From: Simon Davis
Sent: 12 November 2018 11:05
To: Planning.Responses
Subject: FW: Planning Consultation on: AL/57/18/OUT

2nd comments from Independent Design Review Advice Consultation

Thank you for forwarding the consultant's comments upon our proposals. I must say that my heart sank when I saw the attached drawing suggestions and the reason is because they do not capture all that we have considered to be of importance in our response to this site. These are the four main considerations for us:

Drawing Title Proposed 3 Bed Type 2 Elevations

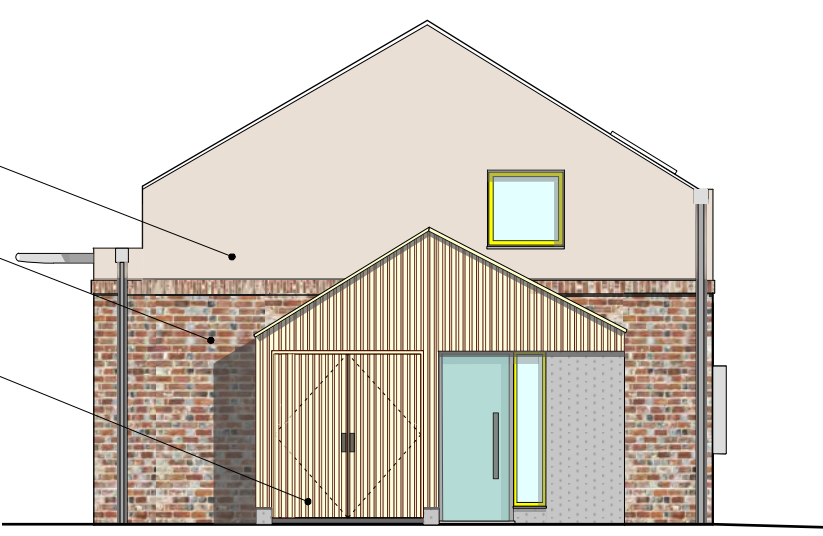
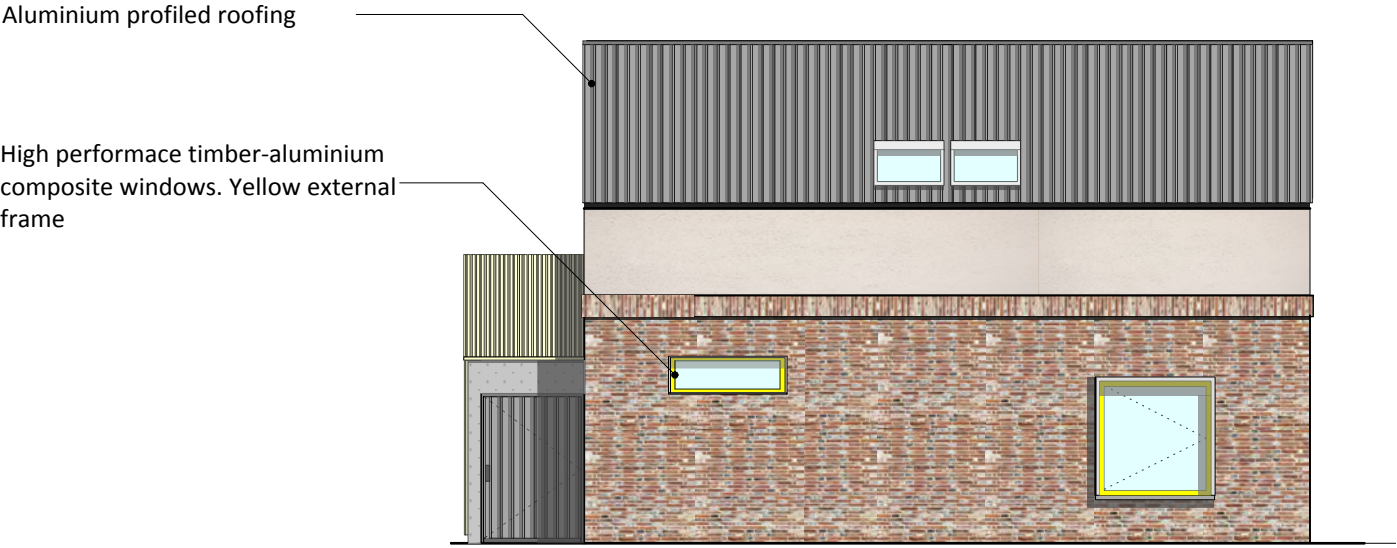
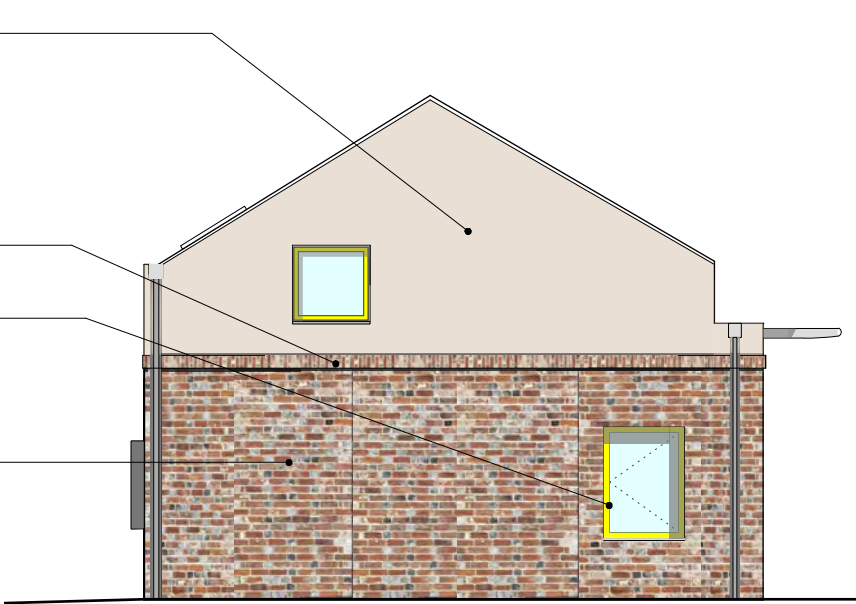
Additionally, given the core intent for maximising solar gain/ minimising heat loss, it was also noted that there is limited variation between the current north and south elevations of the apartments.

It is understood that materials have been selected to support Passivhaus qualities. However, at present, it is unclear how these relate to a local context - this is significant to ensure that new development will become well integrated with the existing community rather than a self contained entity.

We have positioned our buildings, as best we can, to have facades open and oriented to the south and more closed to the north.

We have devised an original cross section through the house types to permit greater penetration of sunlight into the depth of the plan. In all accommodation we have sought to link open plan living areas to the south facades so that we achieve maximum benefit from passive solar gains.
